CITY OF PORTLAND

BUILDING PERMIT

Located At 15 ALLISON AVE

has permission to build a new single family residence with an attached garage.

CROSS SECTION
SCALE: 1/4" = 1'-0"

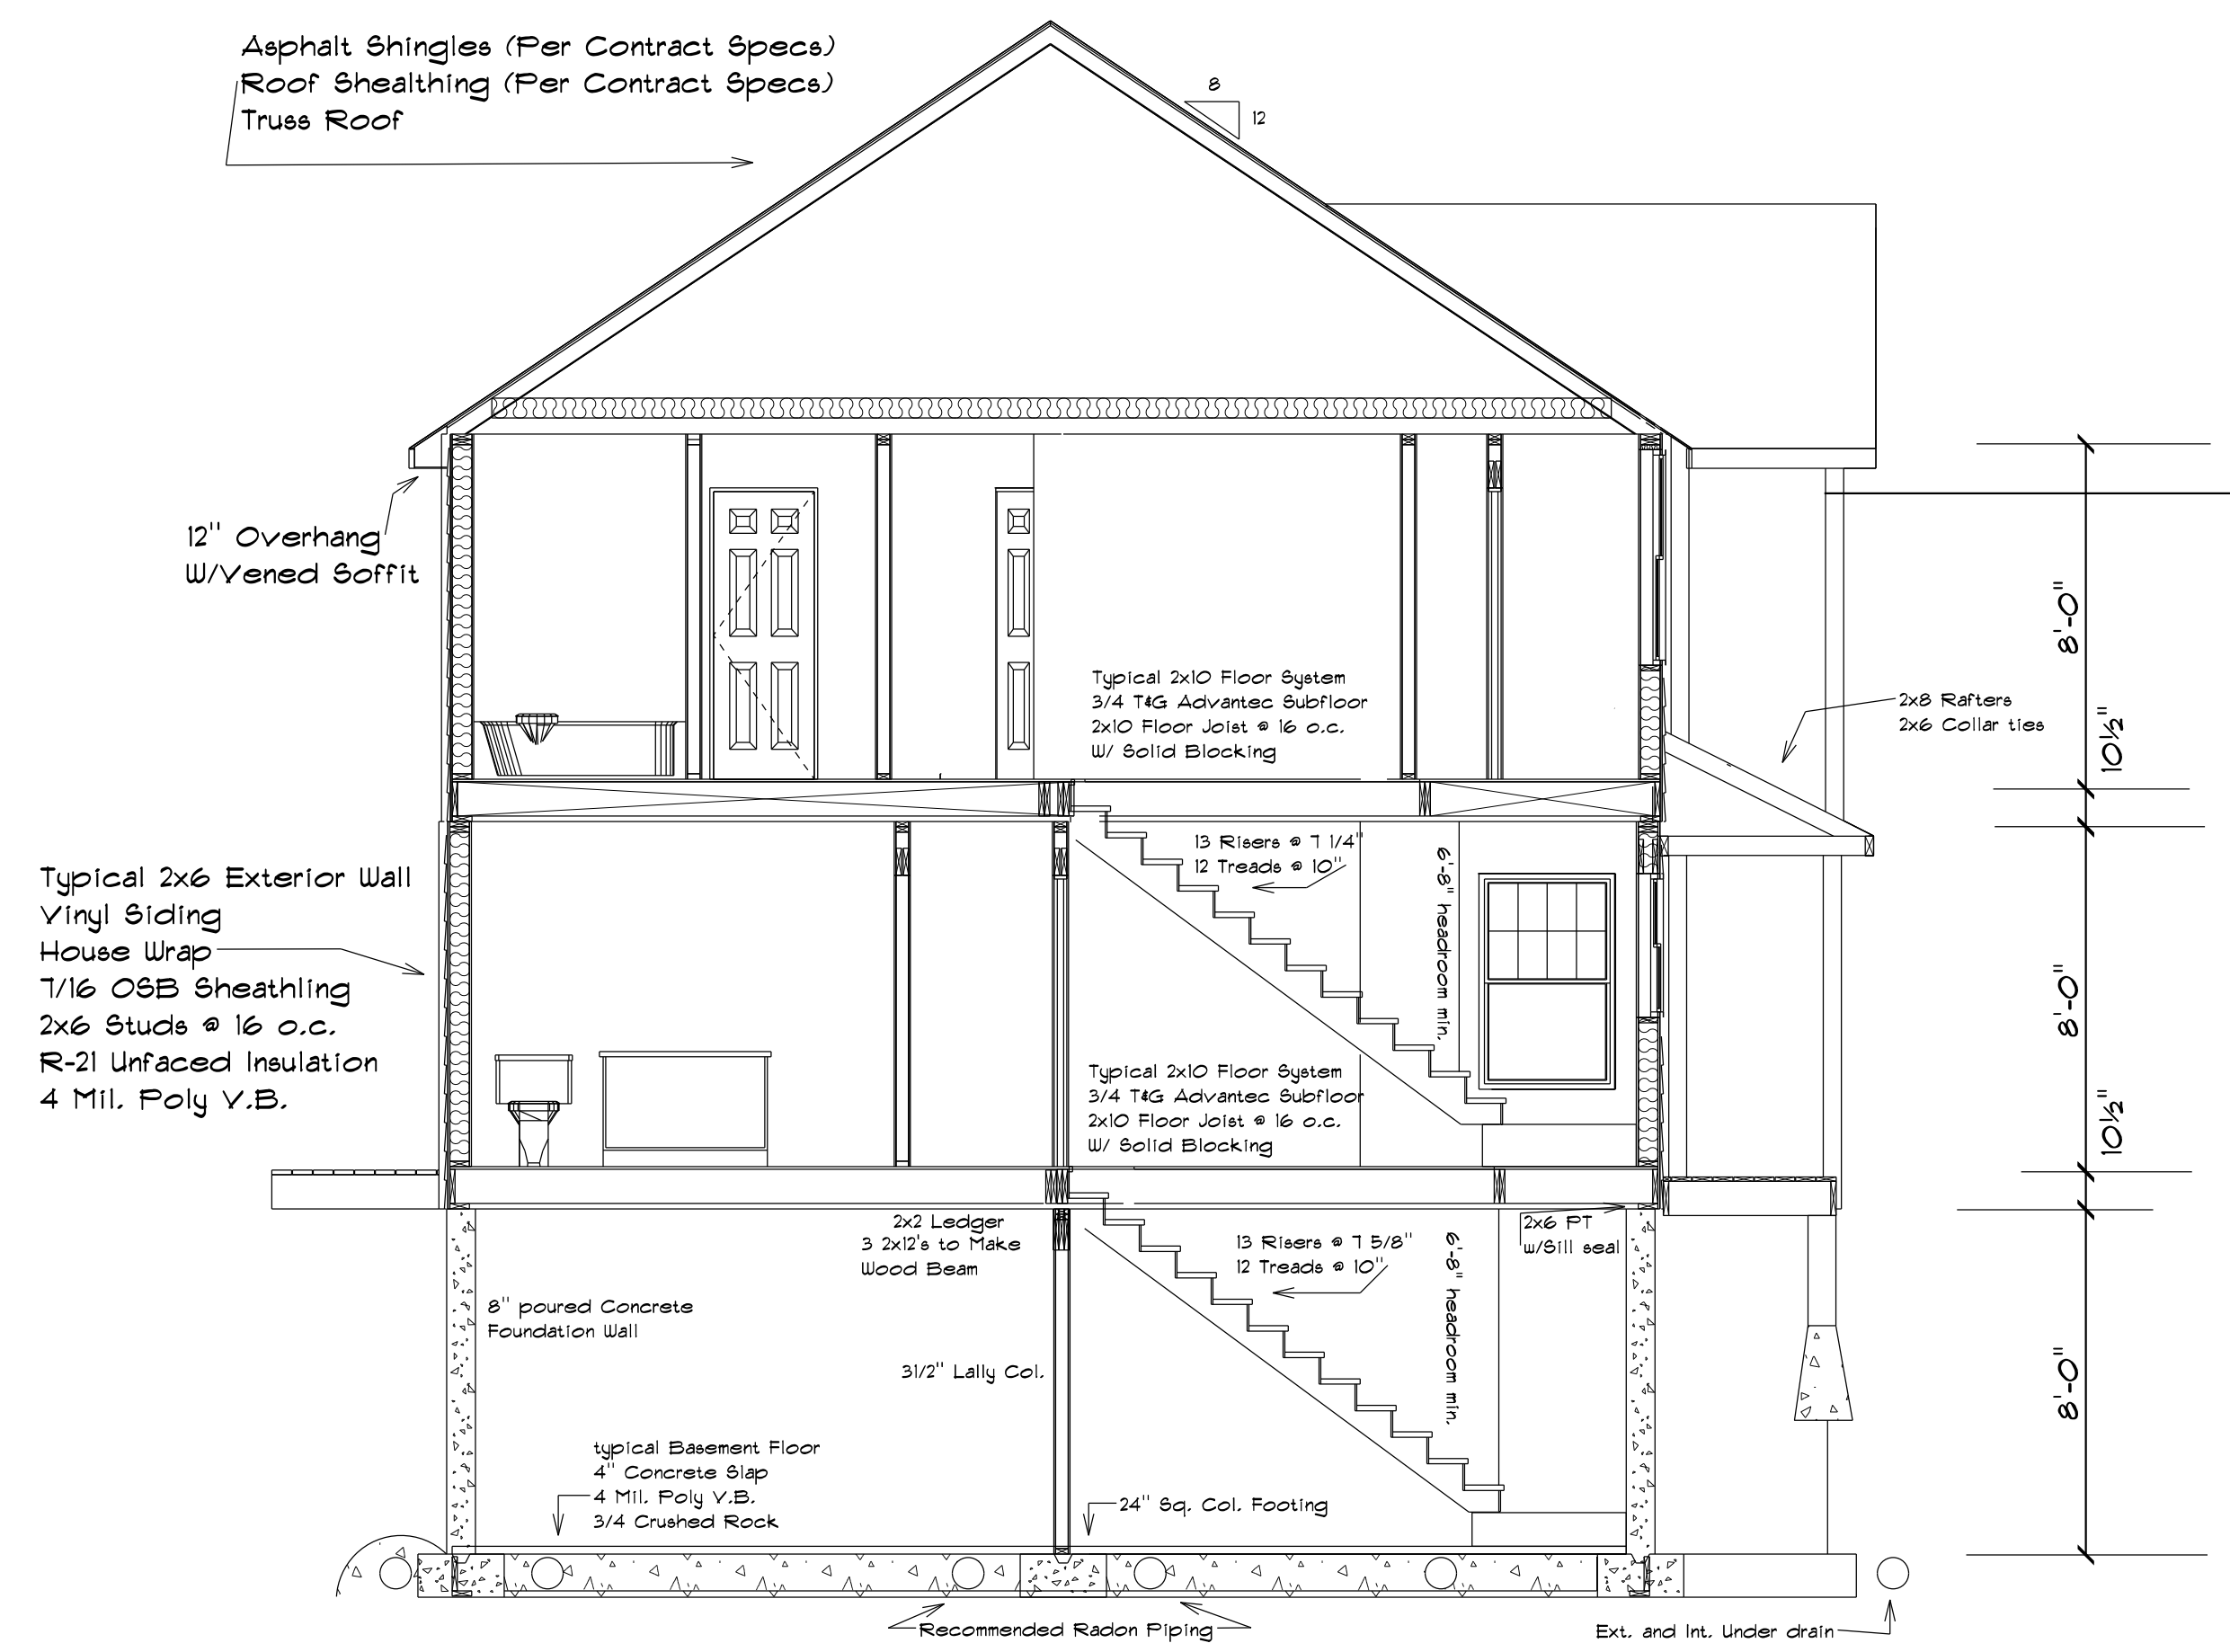
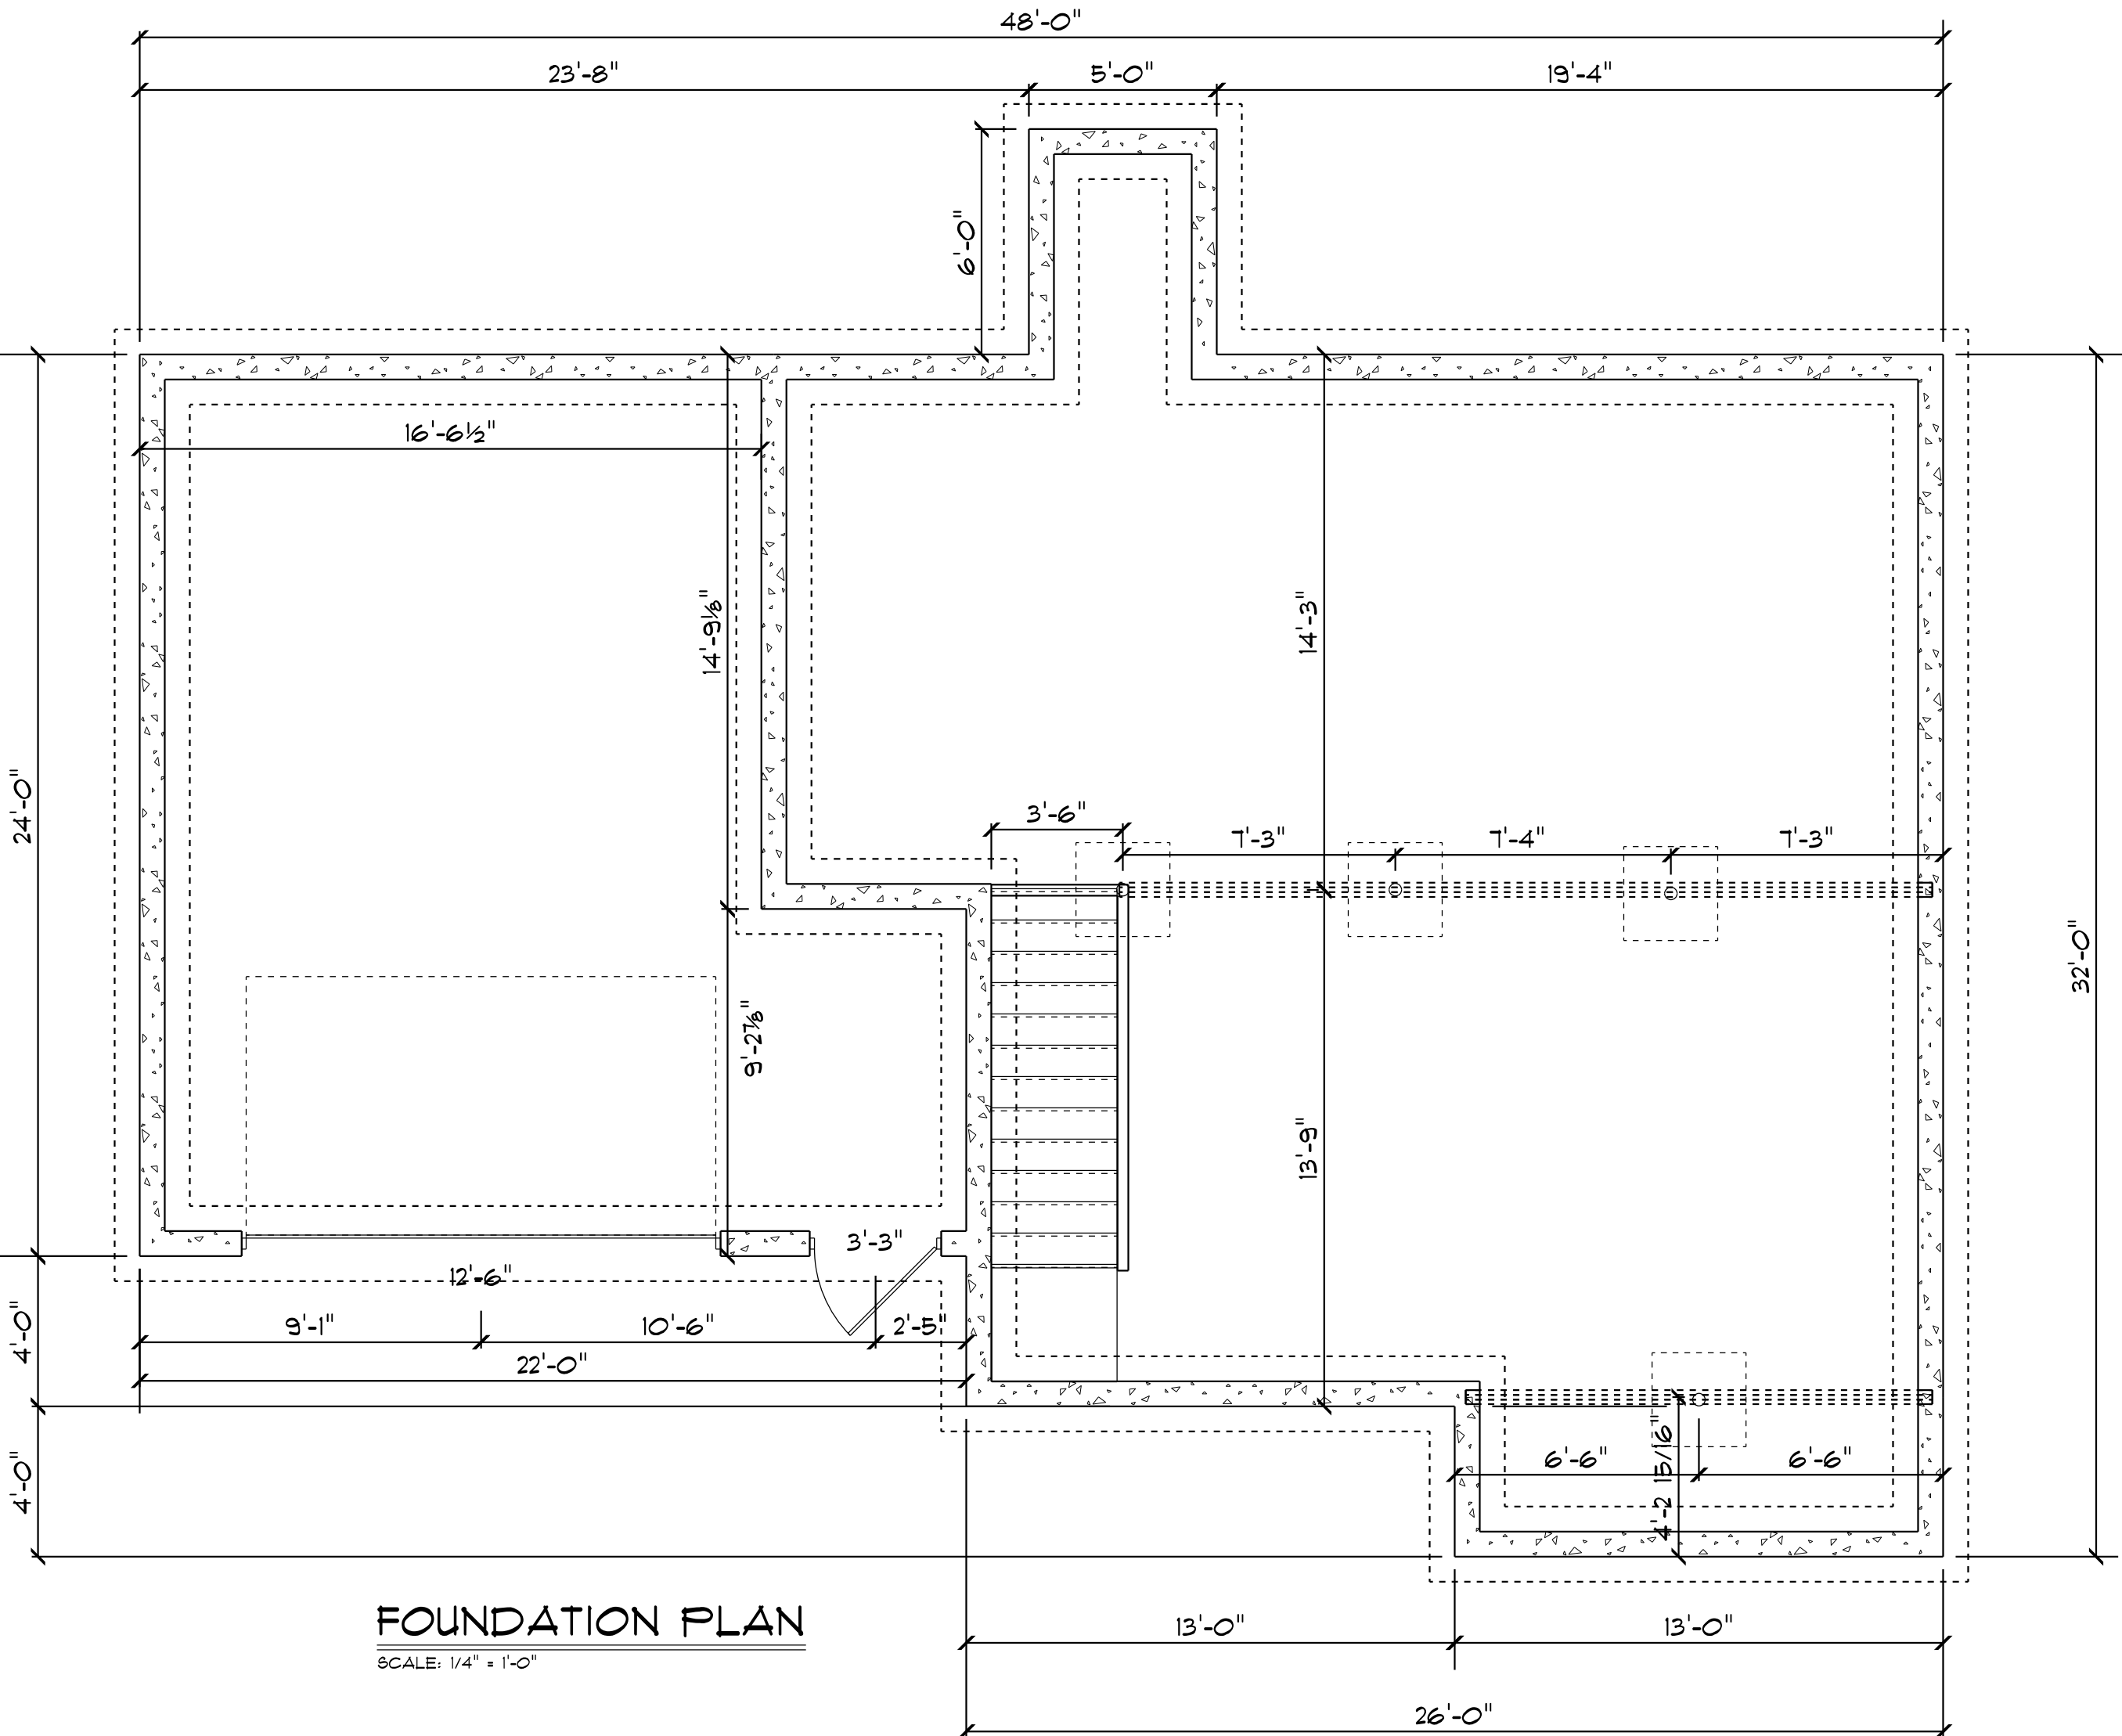
The information below was missing on the building permit application. The floor framing plans/ cross sections need to indicate the (3) 2 x 12 girder spans/ spacing between each lally column; the roof framing plan must show how the dormer meets the 2 by 10 inch rafters, with finished headroom. All bulleted items require a response for permit issuance.

- Footing Dimensions/Depth 20" x 10"
- (Table R403.1 & R403.1(1), (Section R403.1 & R403.1.4.1)
- Foundation Drainage, Fabric, Damp proofing Indicated in the cross section but not spelled out. Also clearly shown in the drainage design
- (Section R405 & R406)
- Ventilation/Access (Section R408.1 & R408.3) shown in cross section at eaves with propa vent and ridge vent at peak
- Crawls Space ONLY
- Anchor Bolts/Straps, spacing (Section R403.1.6) Bolts at 6' o.c.
- Girder & Header Spans between lally columns? (Table R 502.5(2)) on foundation plans
- Built-Up Wood Center Girder shown in cross section

- **Dimensions and Spacing** (Table R502.3.1(1) & Table R502.3.1(2))
- Attic or additional Floor Joist Species
- Dimensions and Spacing (Table R802.4(1) and R802.4(2))
- Dormer pitch, Span, Spacing & Dimension (Table R802.5.1(1) - R 802.5.1(8)) shown in cross section

- **Roof Rafter; Framing & Connections (Section R802.3 & R802.3.1)**
 - **Rafter tie connection to top plate?** not shown but I use H2.5 hurricane clips
- **Fastener Schedule (Table R602.3(1) & (2))**not shown
